CITY OF ALBUQUERQUE

November 18, 2021

Re: Albuquerque ER & Hospital
4315 Wyoming Blvd. NE
Traffic Circulation Layout
Engineer's Stamp 11-09-21 (G19-D004D)

SHEET TITLE
**TRAFFIC CIRCULATION
LAYOUT**

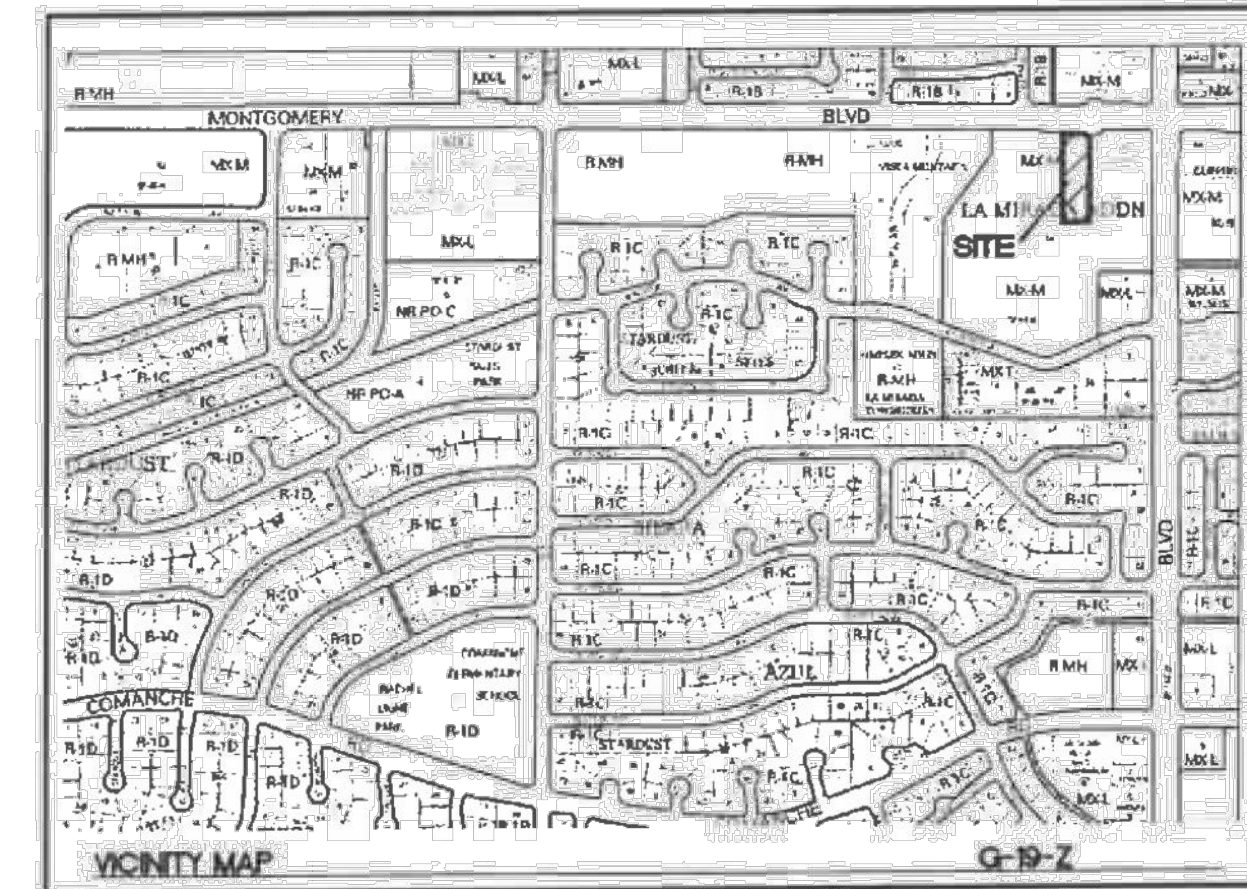
1. Key note 18: Proposed driveway access Ramp on-site plan is not per COA standard DWG. Please modify the site plan.
2. Site plan showing that ADA Van access aisle is 8', but the details sheet shows 7'. Please address this concern.
3. The ADA accessible spaces must include an access aisle. Van accessible aisles should be 8ft wide; all others should be 5ft wide.
4. ADA Van accessible aisle: Per DPM, a 6 ft. wide ADA accessible pedestrian pathway is required from the ADA parking stall access aisles to the building entrances. Please clearly show this pathway and provide details.
5. ADA Parking space: It appears there will be a conflict between the overhang vehicle and the proposed ADA sign. Please address this concern.
6. Provide Fire Marshal Approval.
7. Provide a copy of Approved Preliminary Plat. (This is a condition for approving TCL)
